# **WESTECH COMPANY**

September 28, 2018

In accordance with your comments, ESAs comments and Public Comments on the permit application for a single family residence at 8114 West Mercer Way, Westech Company revised our Mitigation Plan and Monitoring Plan Report (dated September 2018) which has been submitted to you by Mr. Benny Kim. As you have also requested, this letter discusses the various comments on a point-by-point basis. I hope that this is helpful information.

## **Land Use Review Comments**

Figure 4. Site Plan Showing Proposed Buffer Reduction and Addition Areas

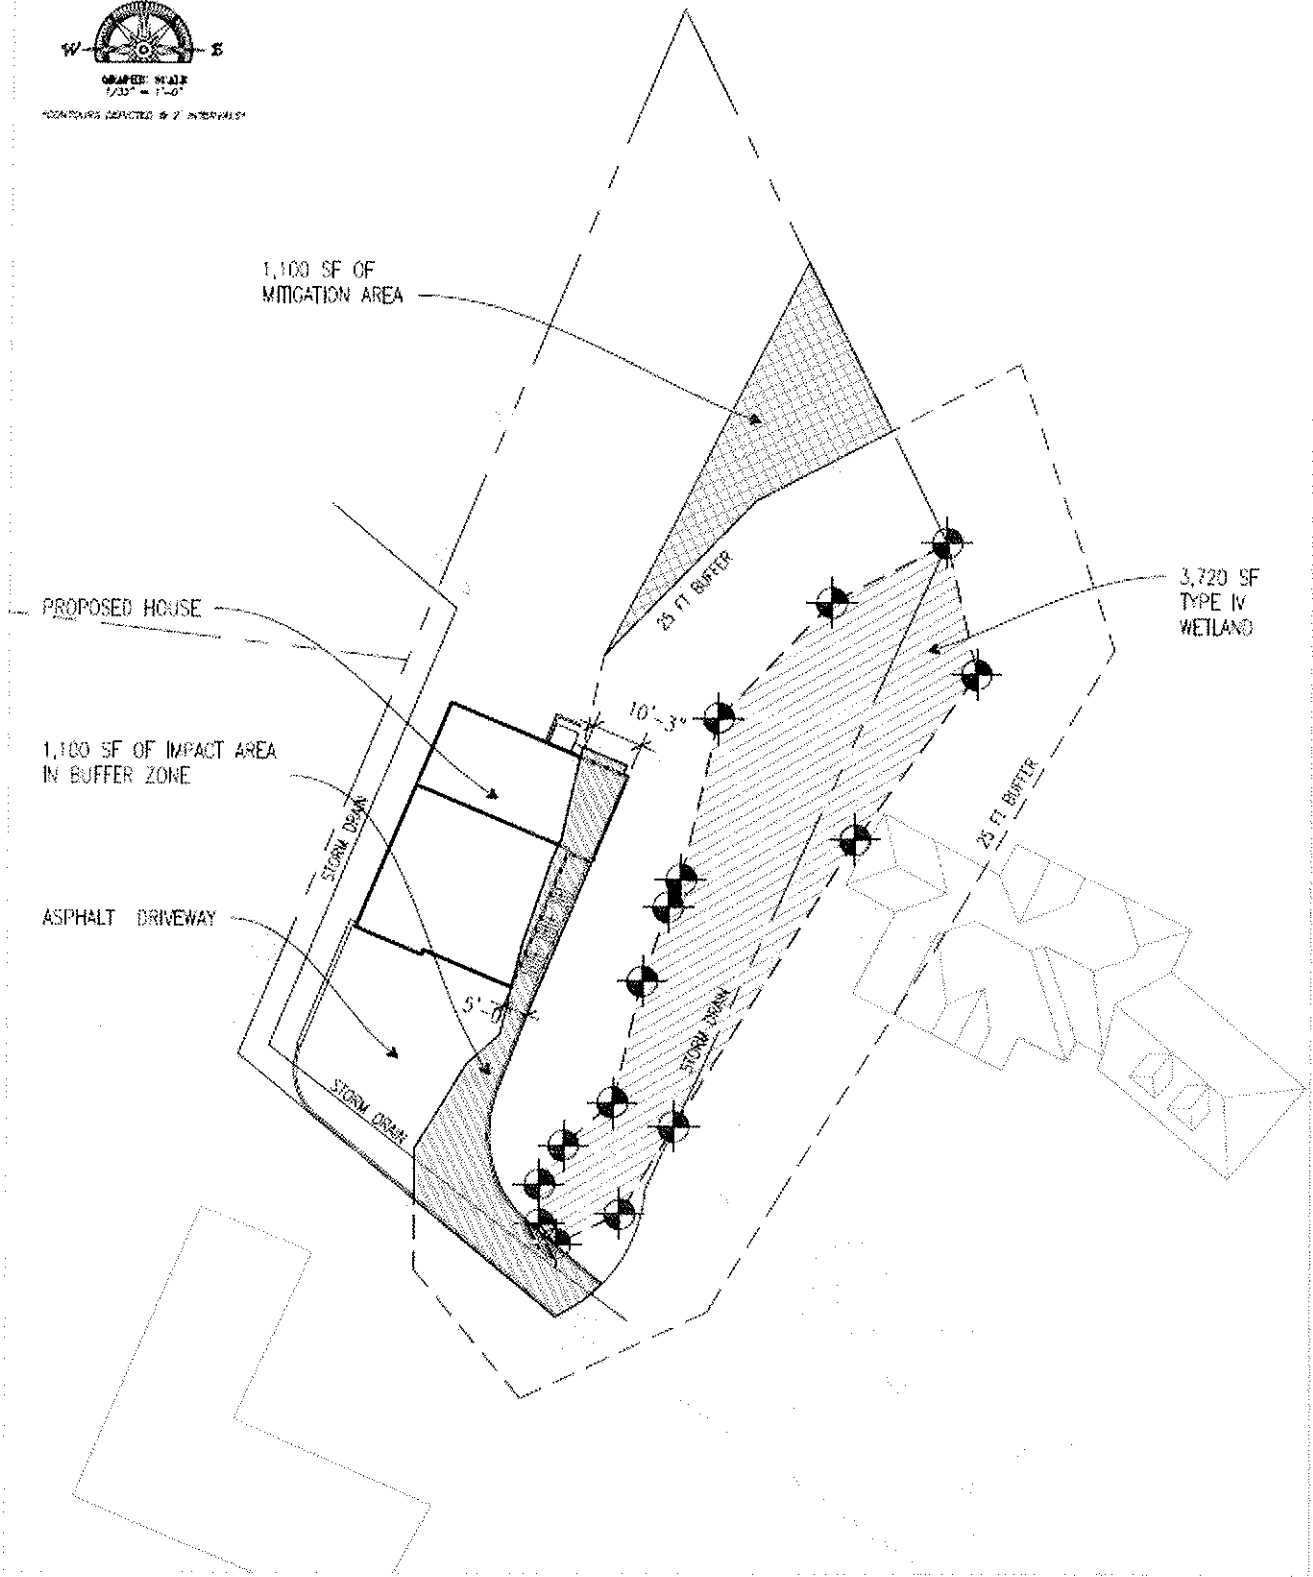
### **1. Options to Proceed**

### **2. ESA Review**

### 4. Site Plan

In response to this comment, the applicant (Mr. Benny Kim) has chosen item (b), and redesigned the residence to lie outside of the minimum 25 foot buffer (see Site Plan in Figure 4, of the Mitigation & Monitoring Plan hereafter M&M Plan). The new design and mitigation will result in a net improvement of wetland function with the new Enhancement Area as shown in that Figure (4). This will comply with MICC 19.07.070(3).

- a) The plan (Figure 4 in the M&M Plan) shows the 200 square foot wet area, which was checked and found not to satisfy the requirements of a wetland. A data sheet was appended to the report to demonstrate that finding (Appendix A).
- b) The driveway was narrowed and reconfigured as requested by ESA and a row of trees is required along the north edge of the driveway as requested (see Figure 4 in the M&M Plan)
- c) The house has been redesigned to lie outside the minimum buffer. The driveway dimensions have been reduced to lie outside of that minimum to the extent feasible and trees have been required to off-set any residual impact and protect the wetland as requested by ESA.

- a) The new Site Plan has been revised to show the 25 foot(minimum) and 35 foot (standard) buffers adjacent to the house site.
- b) The 200 square foot “wet area” was studied further and found NOT to constitute a wetland (see Figure 4, Chapter 5.0 and Appendix A of the M&M Plan).
- c). The off-site buffer has been removed from the Plan.
- d) The reduced buffer has been shown for the house and the driveway as requested.
- e) This information regarding steep slopes has been added to the Site Plan.
- f) This information regarding easements will be submitted under separate cover.
- g) This information regarding the property line and dimensions has been added to the Site Plan.

Figure 5. Planting Areas to Provide Buffer Restoration and Enhancement

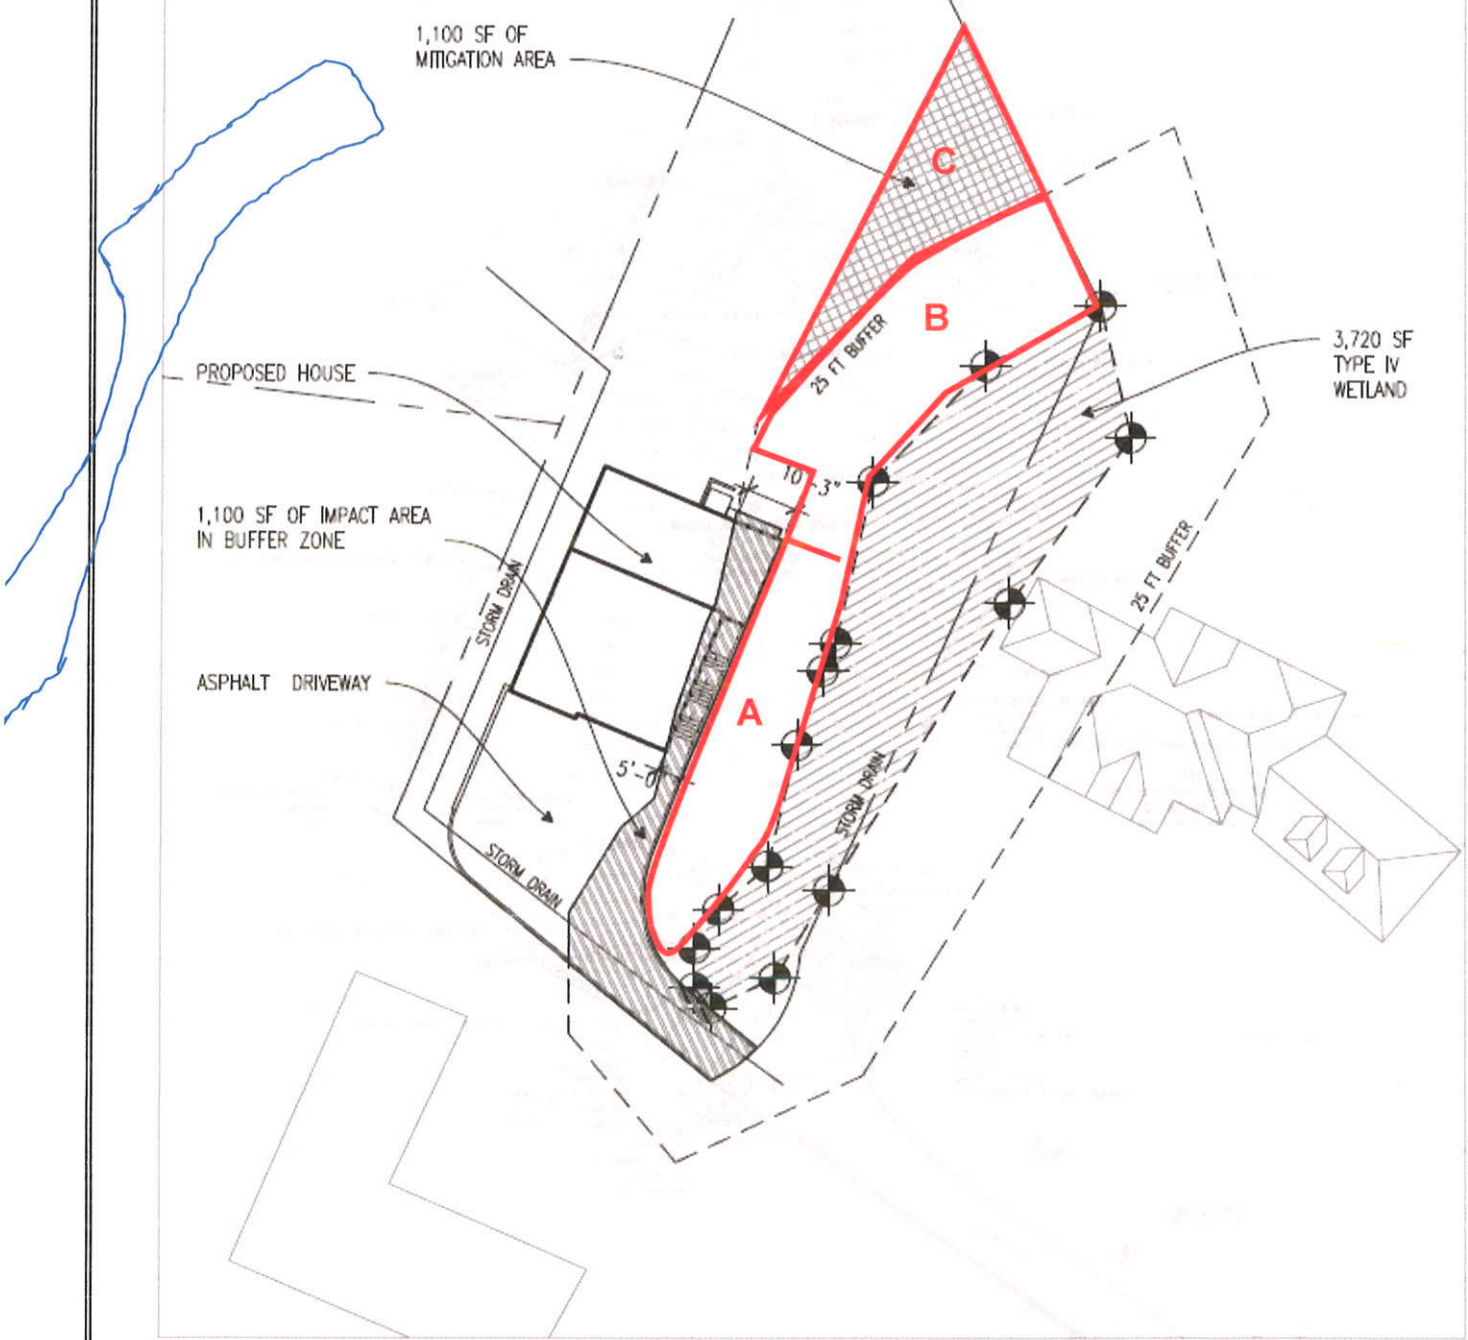
### 3. Public Comment

- b) Water on-site: Concerns about erosion and run-off and the potential impacts to neighboring sites. Again, C2MY Engineering has prepared an erosion control plan to mitigate impacts during construction. Re-vegetation plans (with native plants) have been developed to stabilize the soils in the construction area. BMPs will be used during construction. Silt fences will be kept in place until new shrubs and trees are established in the Buffer Enhancement Area (see Figure 4 in the M&M Plan).
